From: Karen Boon [REDACTED]
Sent: 03 January 2024 08:44
To: Dennis, Sarah
Subject: Re: Tree Works Application - Thornhill Baptist Church, Thornhill Park Road, Southampton

From: Dennis, Sarah [REDACTED]
Sent: Monday, December 4, 2023 2:54 PM
To: Karen Boon [REDACTED]
Subject: Tree Works Application - Thornhill Baptist Church, Thornhill Park Road, Southampton

Figure 1- Tomographic image

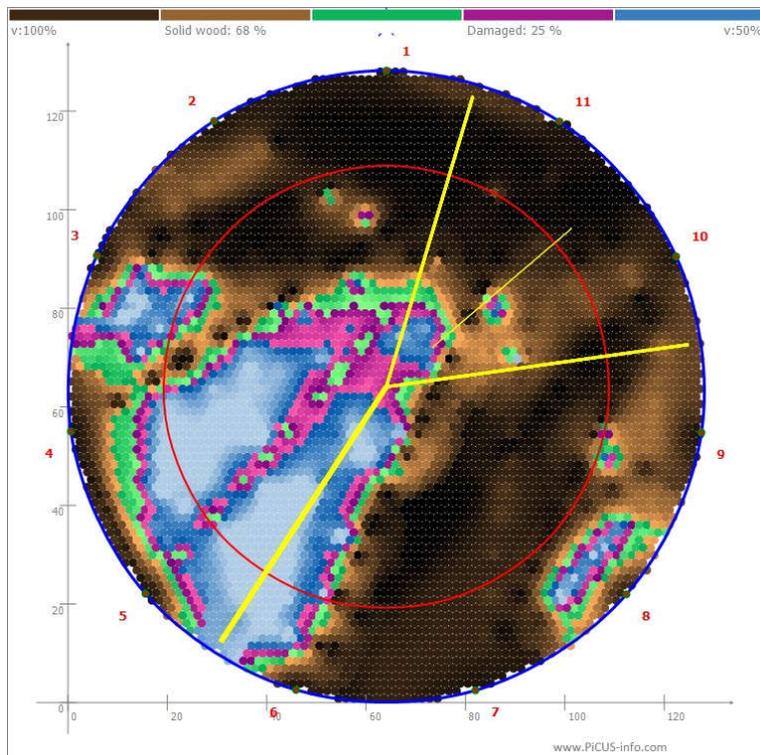
T14 & T16 – Please could you specify how much you are intending to reduce the selected branches by.

1. Yes
2. T11 - Remove limb of neighbour's chimney stack. Crown raise to 4m above Car park. Remove all deadwood for safety reasons (overhanging car park).
3. T14 & T16 Remove all deadwood and dieback. Crown reduce by 2-3m.

**TREE SITE PLAN**

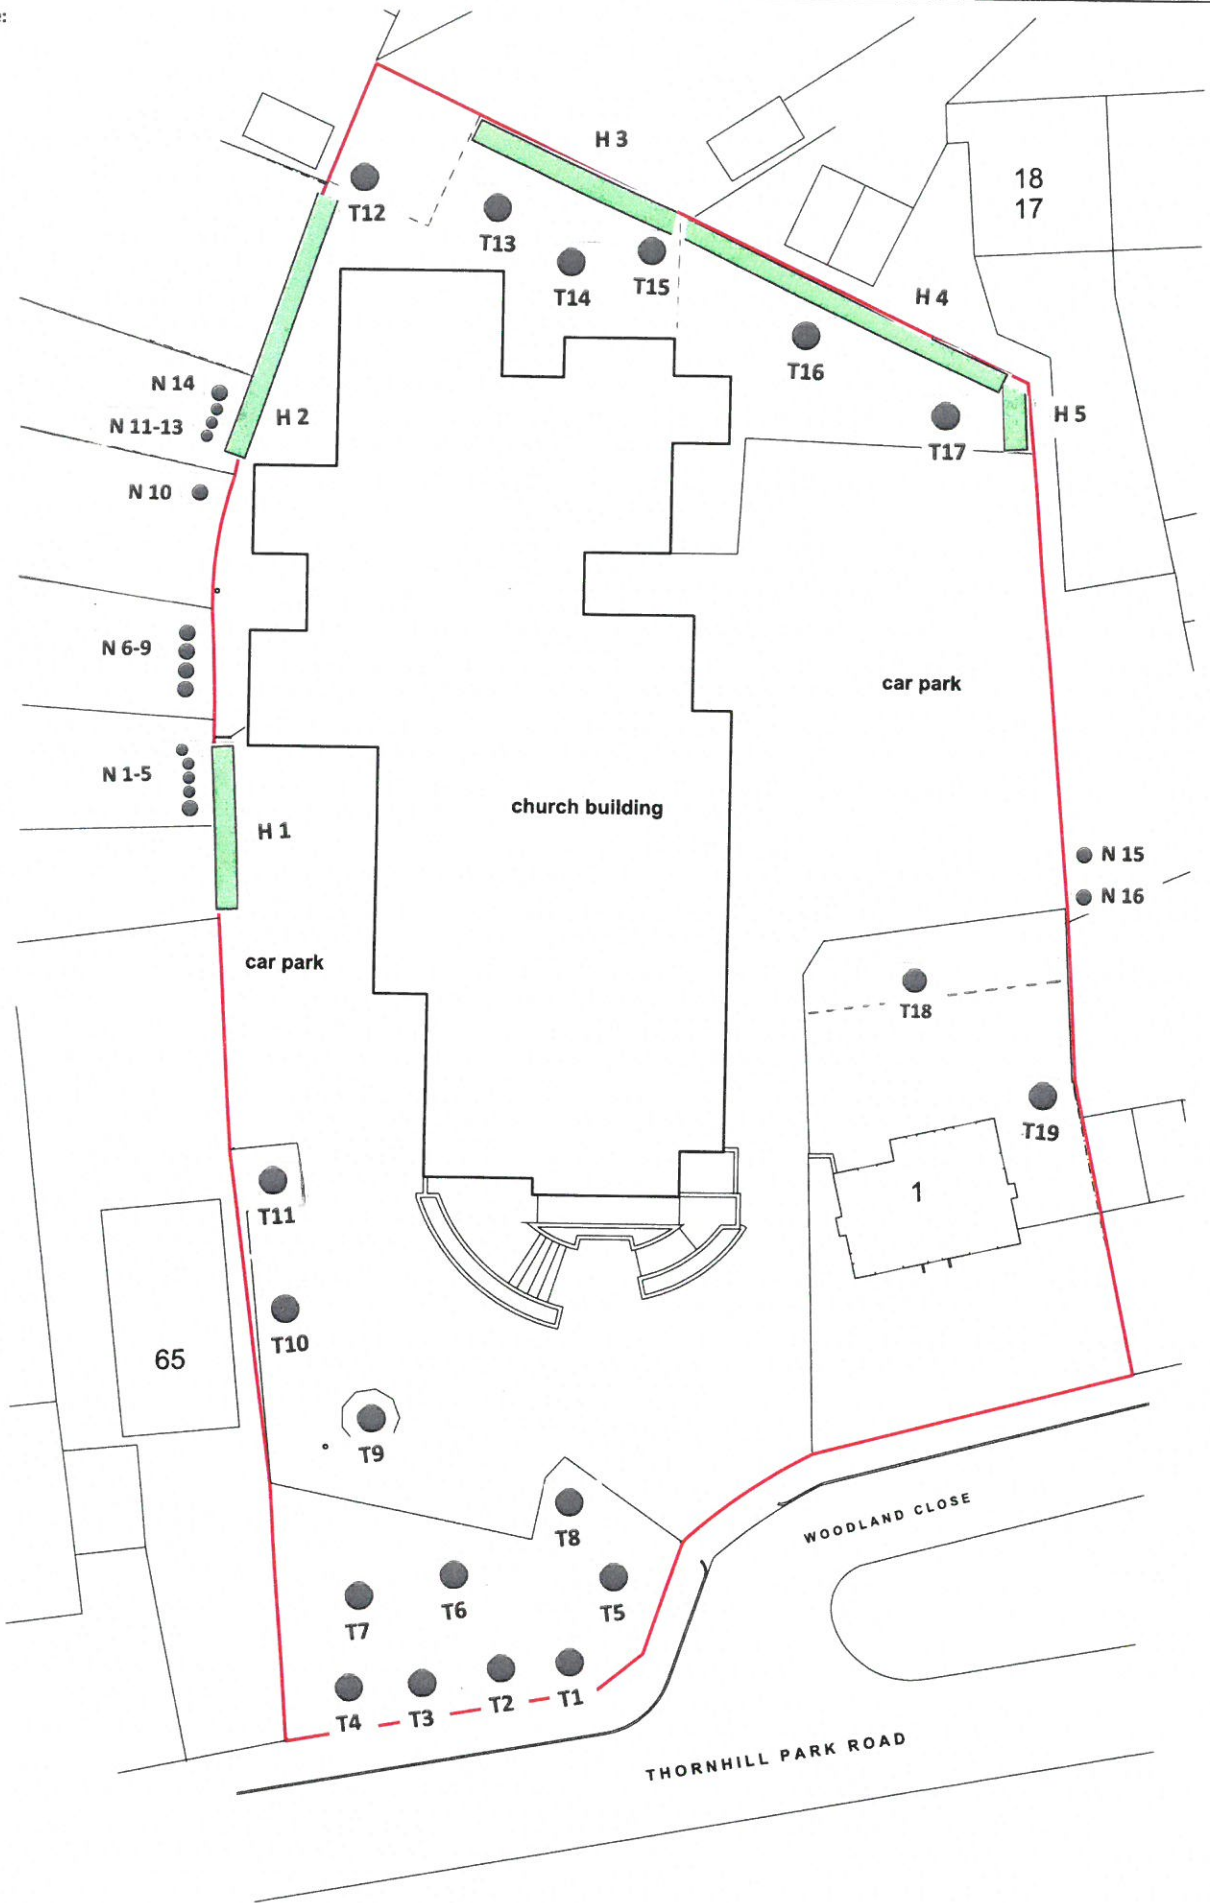
T11 – Please could you confirm if you are removing the whole branch back to the trunk? If not, please could you specify how much you are intending to remove.
